Application No: FP/60/22/HH
Site Address: 8 Wansford Way Felpham PO22 7NL
Description of works: Erection of single storey rear and front extension, conversion of loft to habitable use including the installation of 3 x rear dormers and a first floor balcony following demolition of existing front porch and rear extension/conservatory.

Thank you for your internet representation made on 12th May 2022 which has been recorded as no objection with the comments as follows:

DRAWING TITLE
PROPOSED ELEVATIONS

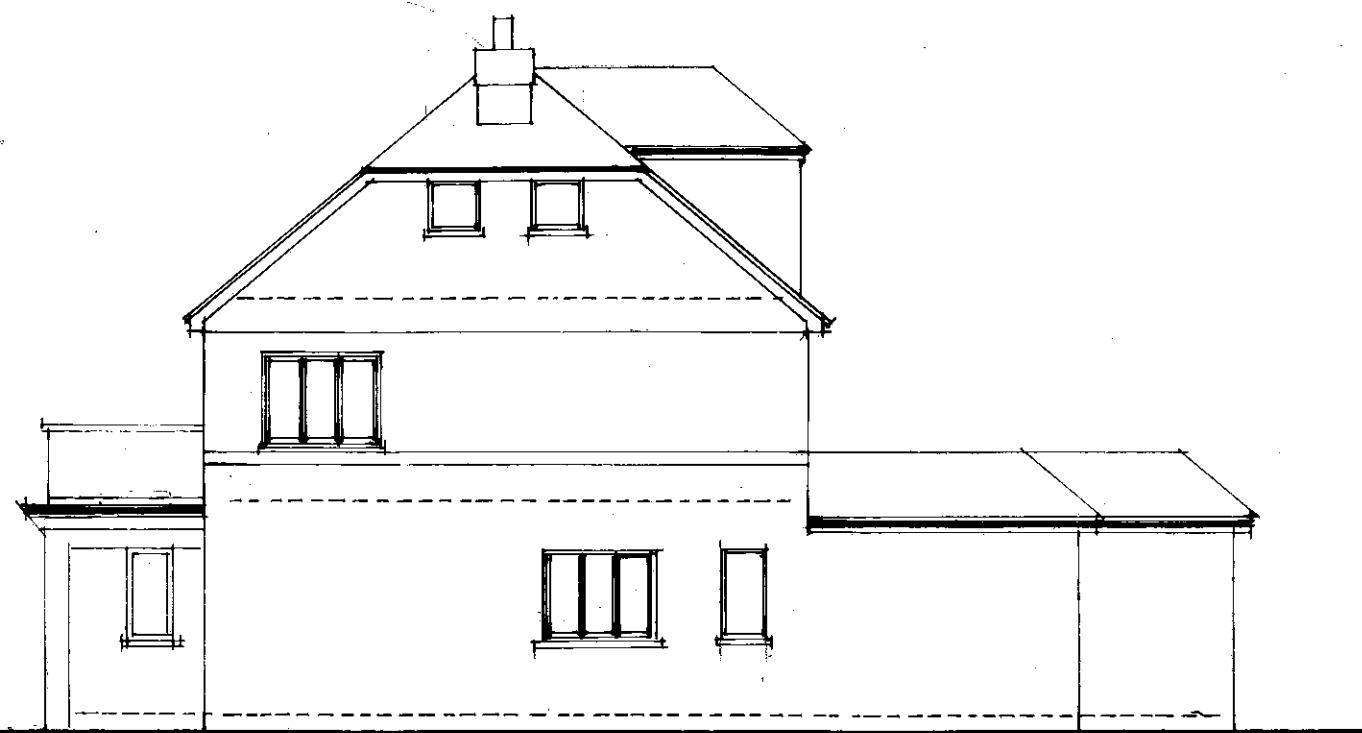
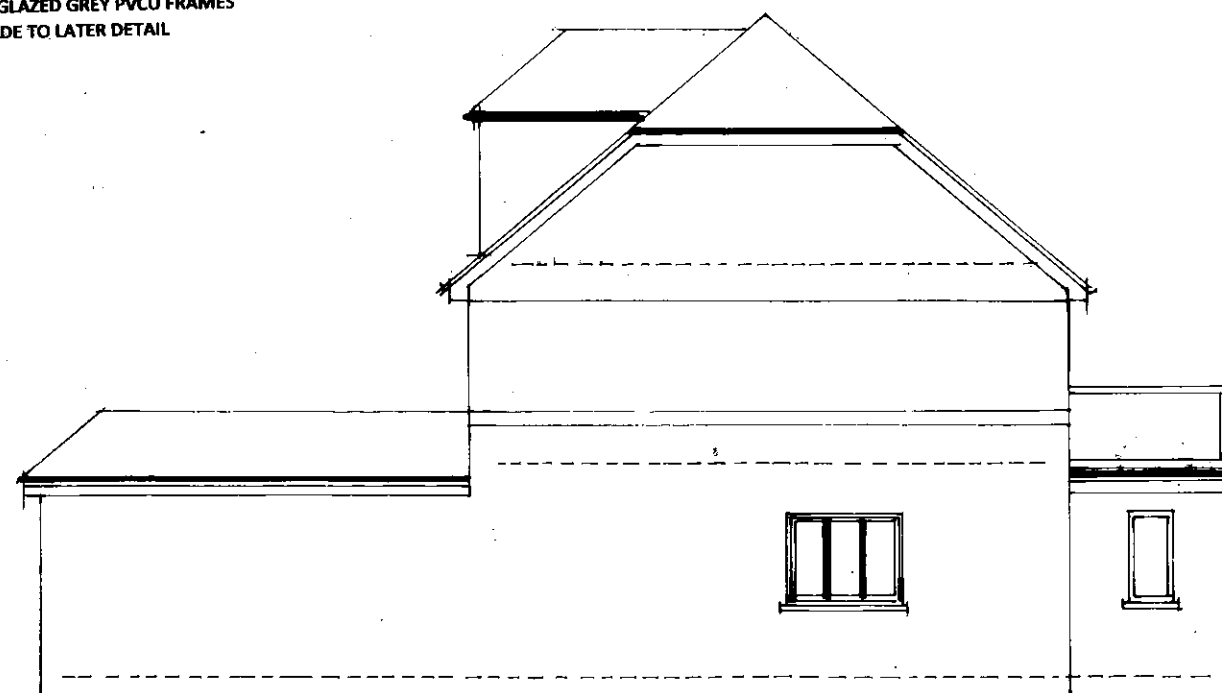
Felpham Parish Council have no objection providing the balcony is obscure glass.
